# CITY OF ALBUQUERQUE

December 1, 2021

**Re: EL Encuentro Immigrant Community Center**  
**907 4<sup>th</sup> Street SW**  
**Traffic Circulation Layout (TCL)**  
Architect's Stamp 10-15-2021 (K14-D121)

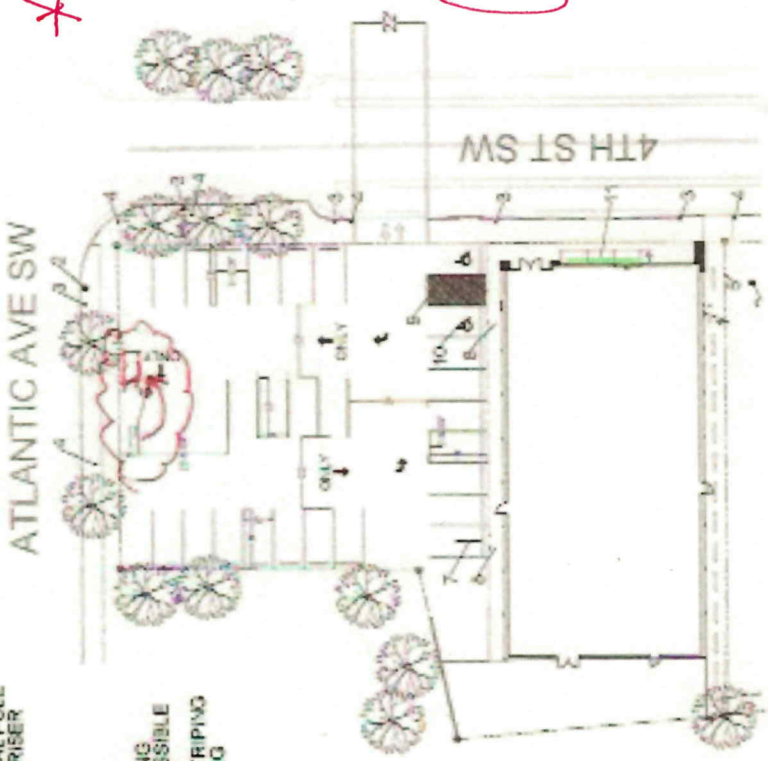
4. Bulb Out off 4<sup>th</sup> Street:
  - What is the purposed for this bulb out? Parking/ Loading Zone? Provide signage to define its function off COA ROW public street.

5. **Lot ( 909 4<sup>th</sup> SW):**
  - The lot belongs to to the Community Center and needs to be shown on site plan **(Being used for over flow parking).**

- There are two drivepads. One drivepad is shared with the northern property and will need to be close as it serves no function at present moment. See comment 26 notes to provide closure notes.

Mayor Timothy M. Keller

19. Per the DPM, a 6 ft. wide ADA accessible pedestrian pathway is required from the public sidewalk to the building entrances. Please clearly show this pathway and provide details.

27. Delete 1-parking stall at drive aisle (south of trash bin) to assure 22 ft of aisle is provided for circulation (If applicable).
28. **Shared Site access (between lots on 907 & 909 4<sup>th</sup> St SW):** driveways that straddle property lines, or are entirely on one property but are to be used by another property, shall have an access easement. Please include a copy of your shared access agreement with the adjacent property owner.

BICYCLE RACK REQUIREMENTS: 3 BICYCLES
SCALE 1" = 10'

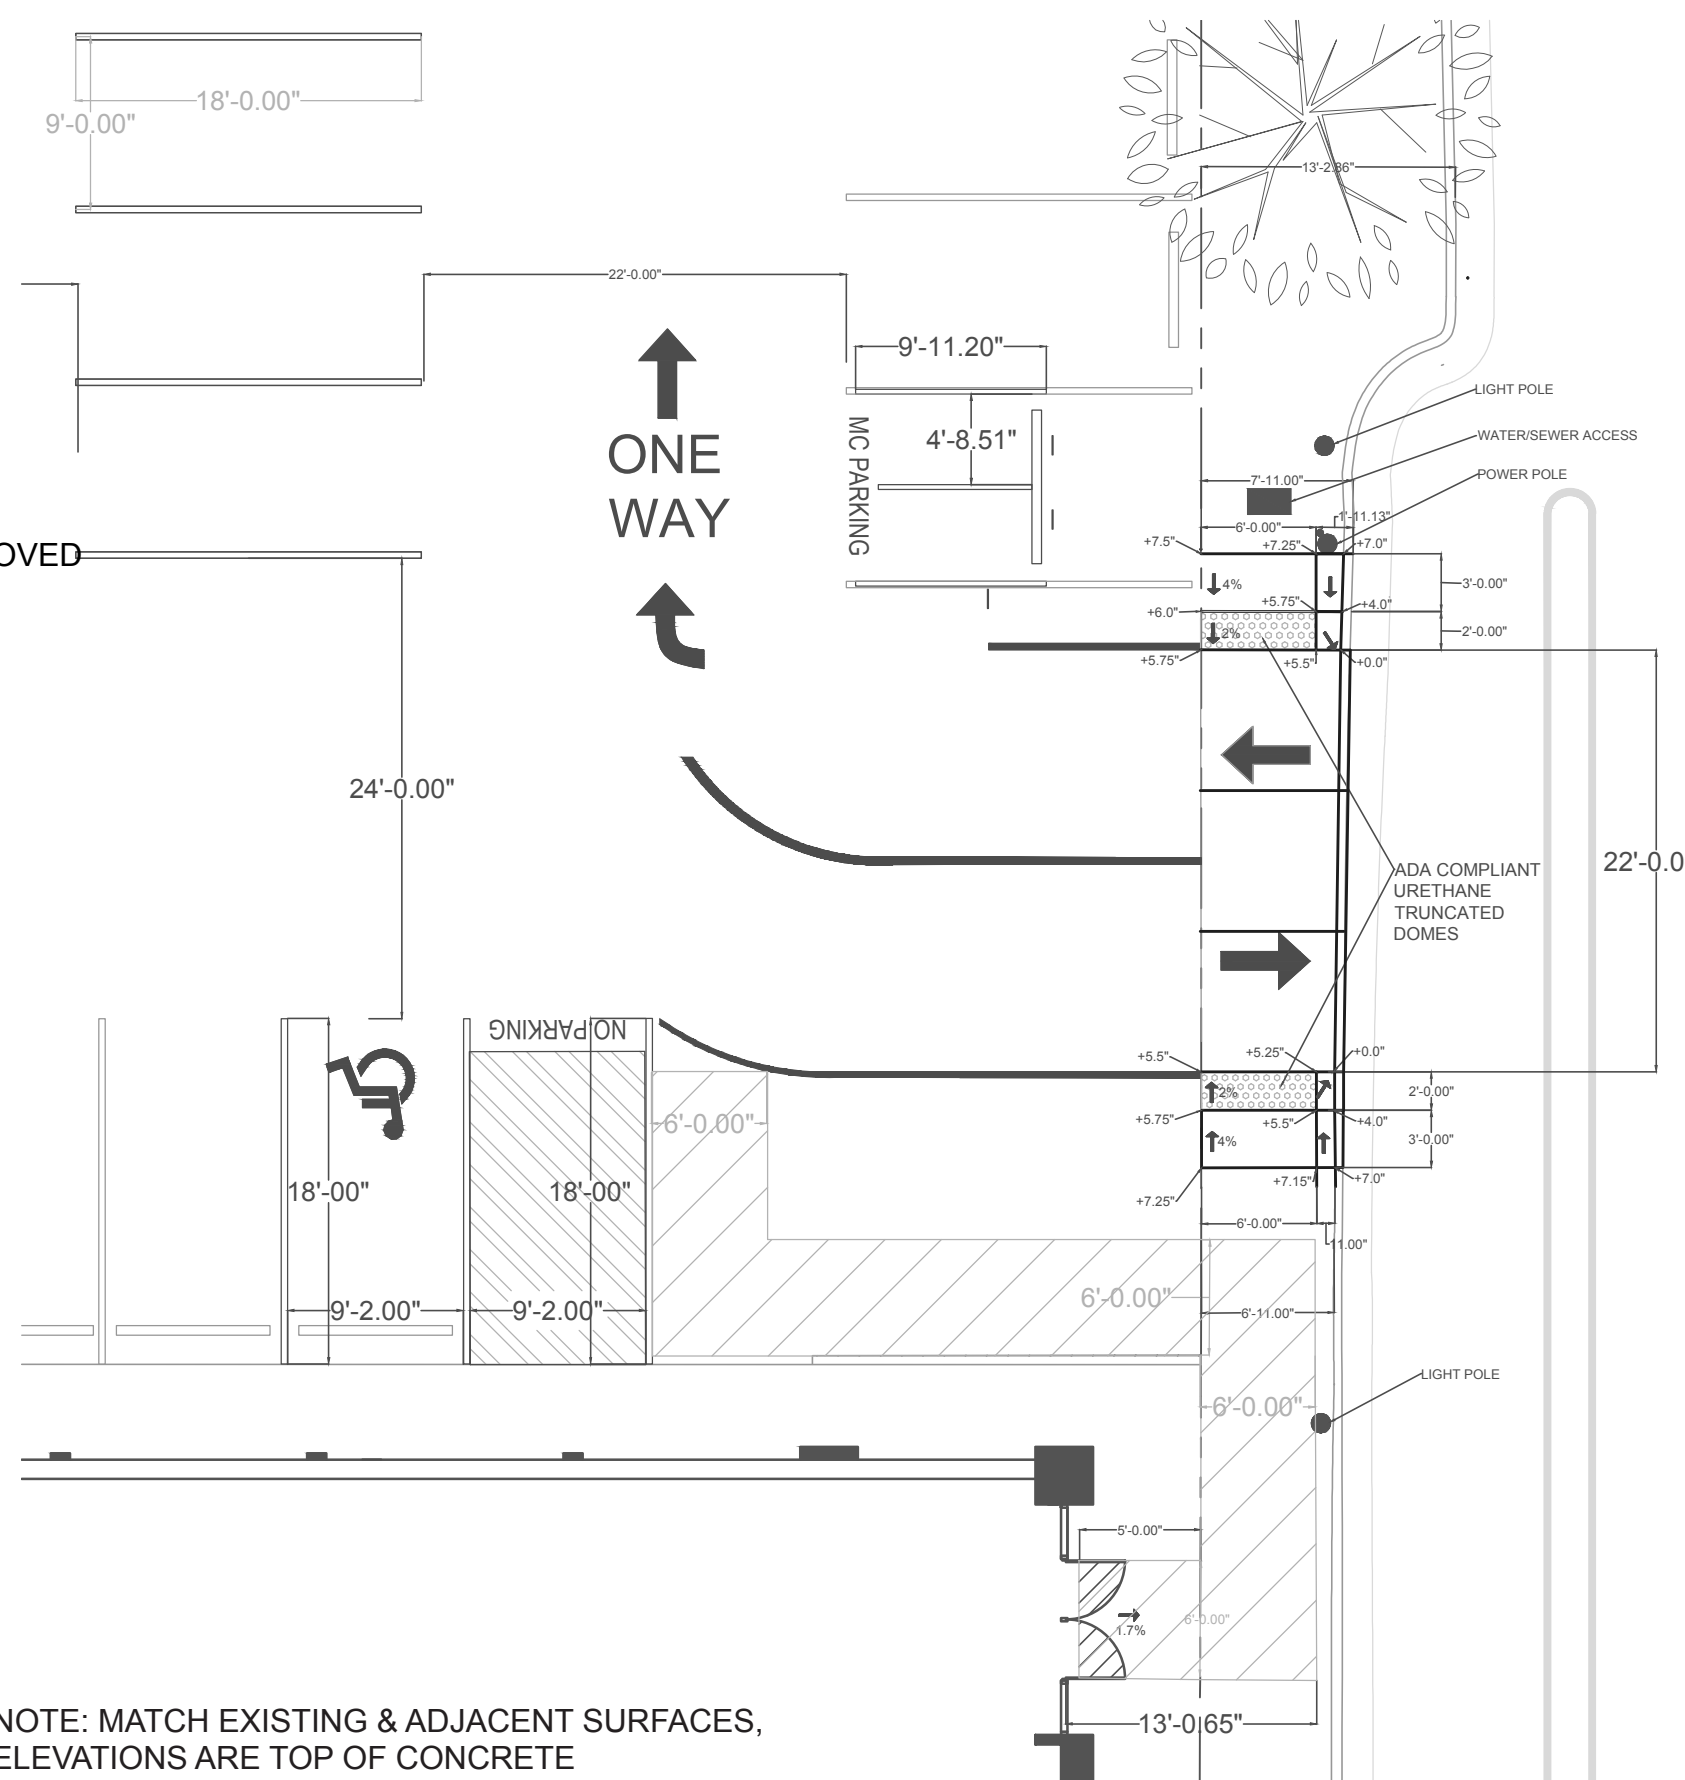
15. All bicycle racks shall be designed according to the following guidelines:
  - a. The rack shall be a minimum 30 inches tall and 18 inches wide.
  - b. The bicycle frame shall be supported horizontally at two or more places. Comb/toaster racks are not allowed.
  - c. The rack shall be designed to support the bicycle in an upright position. See the IDO for additional information.
  - d. The rack allows varying bicycle frame sizes and styles to be attached.
  - e. The user is not required to lift the bicycle onto the bicycle rack.
  - f. Each bicycle parking space is accessible without moving another bicycle.
16. Bicycle racks shall be sturdy and anchored to a concrete pad.
17. A 1-foot clear zone around the bicycle parking stall shall be provided.
18. Bicycle parking spaces shall be at least 6 feet long and 2 feet wide.

PROPOSED DRIVEWAY- LOT A
SCALE 1" = 10'

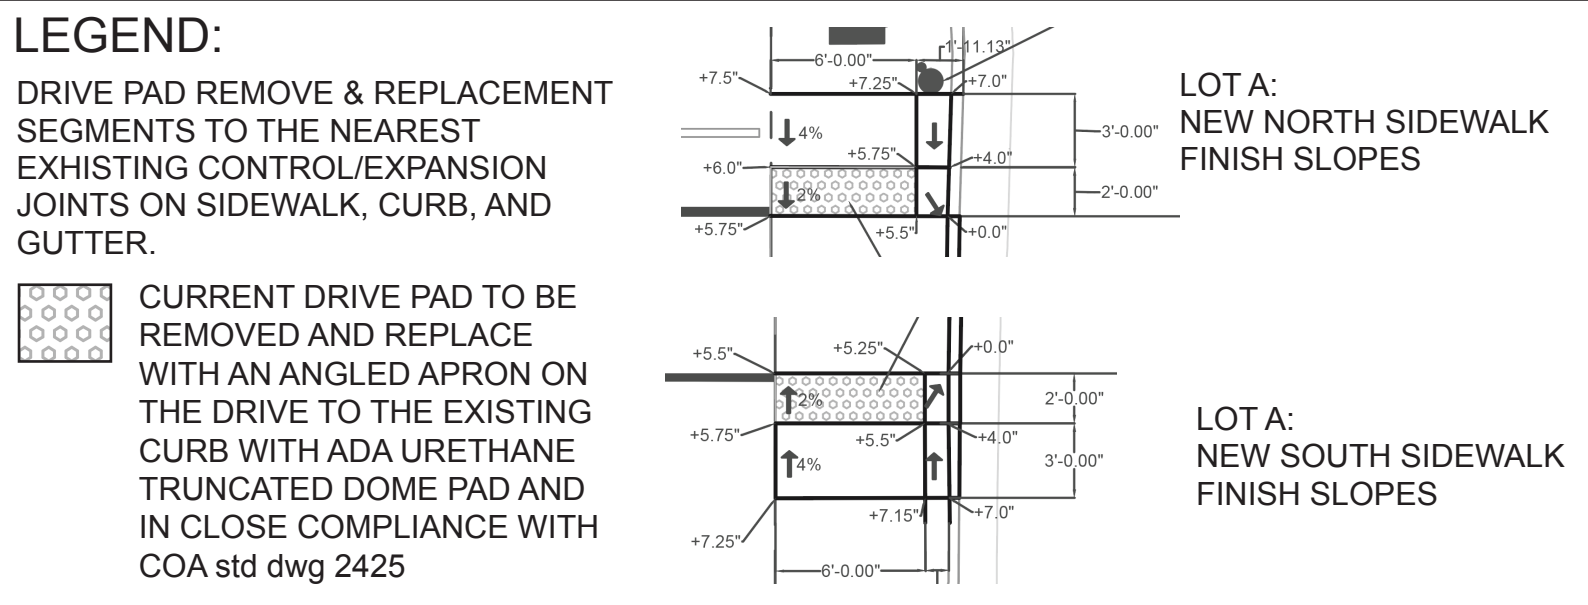
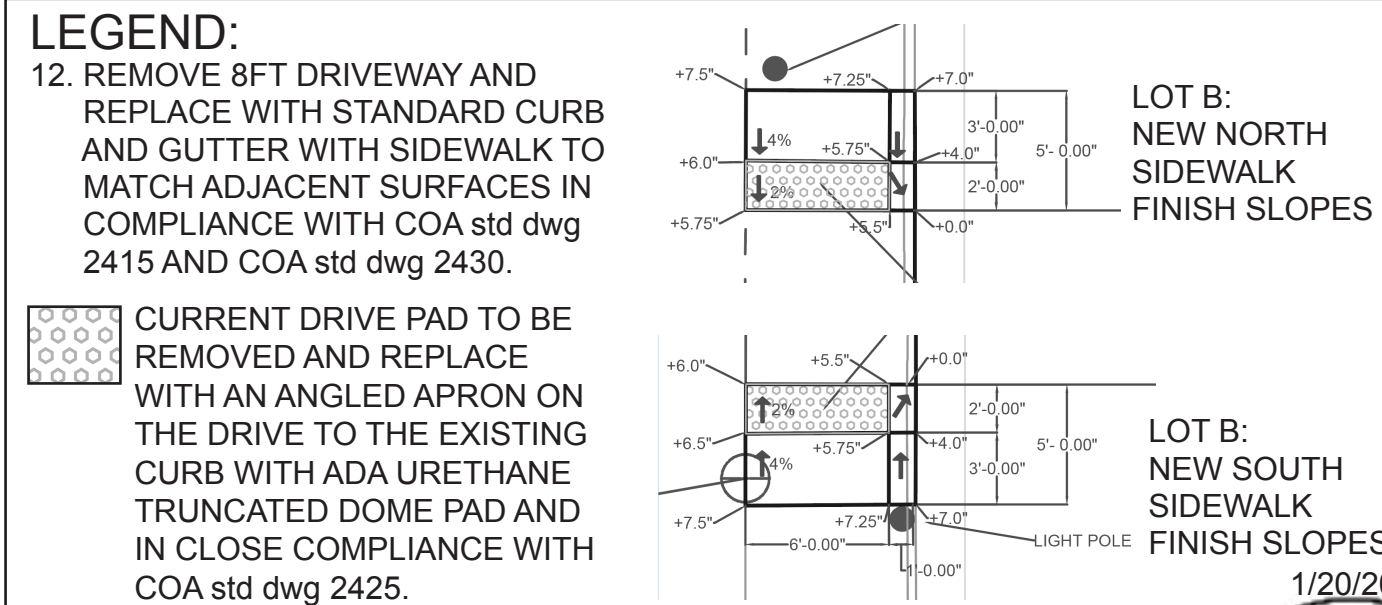
**Coordinate/discuss with Zoning.**
3. Private entrance off 4<sup>th</sup> will need to be modified (curb return type design, review COA std dwg 2426 to comply with this requirement) to address ADA compliance and DPM design requirements.

26. Unused curb cuts must be replaced with sidewalk and curb & gutter. A build note must be provided referring to the appropriate City Standard drawing (2430 & 2415A). This drivepad will need to be close adjacent to power pole and building wall (show closure on plans).

EXISTING/ PROPOSED CORNER
SCALE 1" = 10'

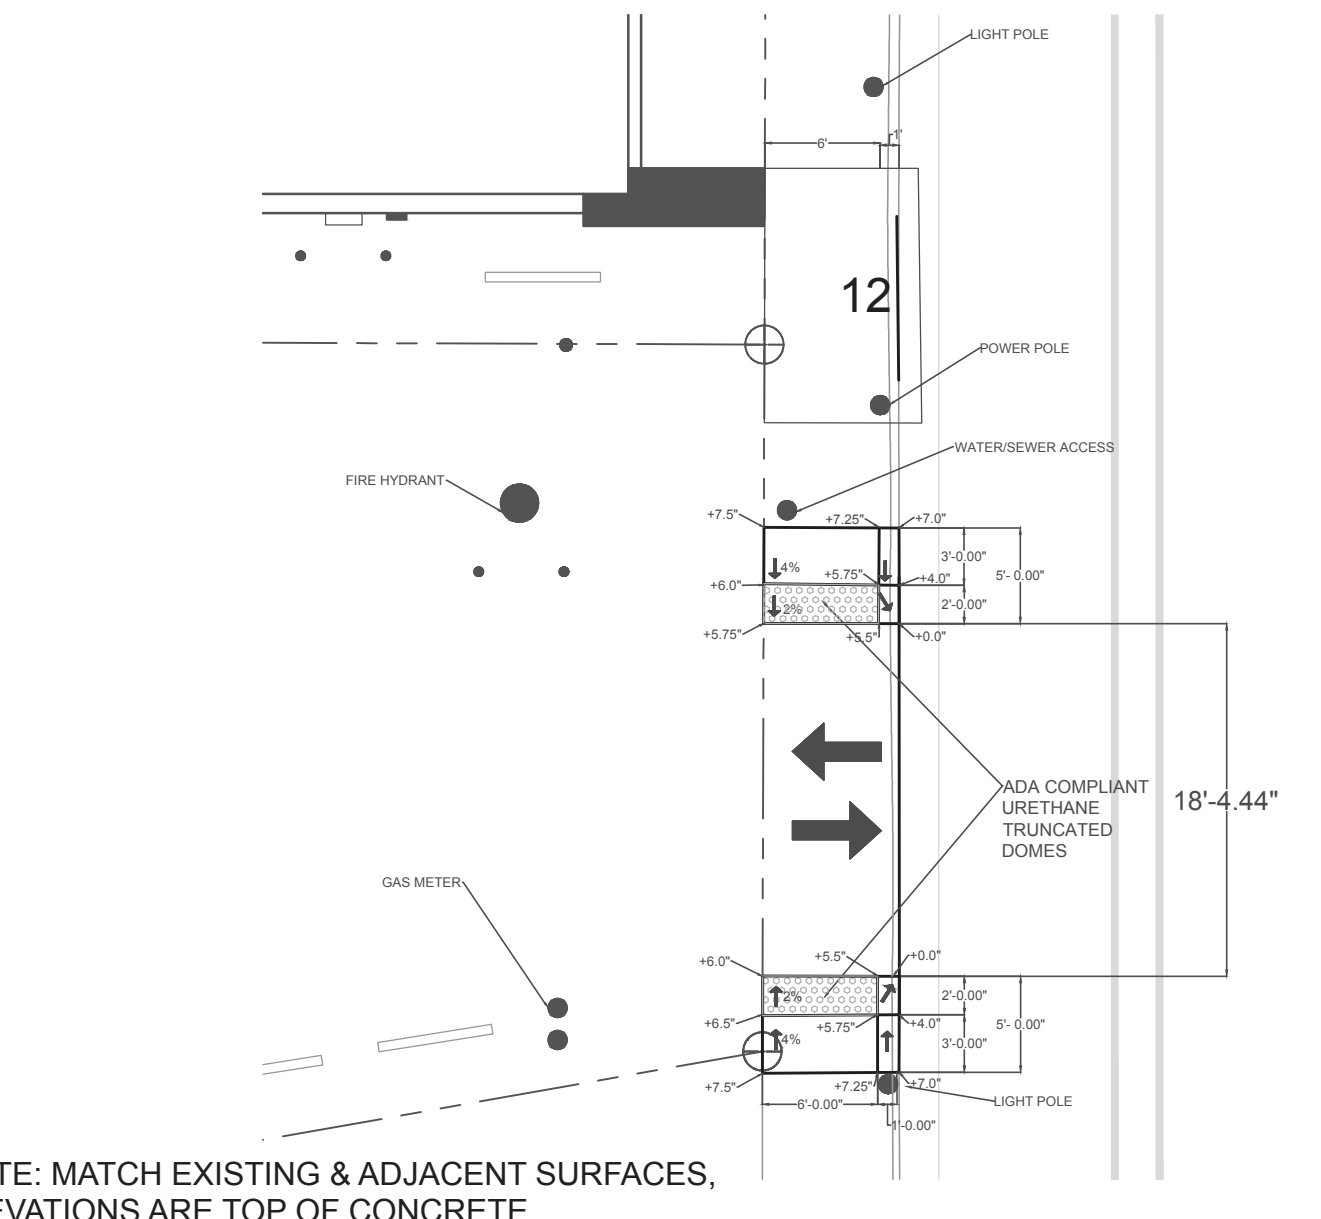
13. ADA curb ramps must be updated to current standards and have truncated domes installed (**Corner of Atlantic/4<sup>th</sup>**). Verify.
14. Motorcycle parking spaces shall be designated by its own conspicuously posted upright sign, either free-standing or wall mounted per the zoning code. Label pavement MC. Provide details for sign face and pavement marking.
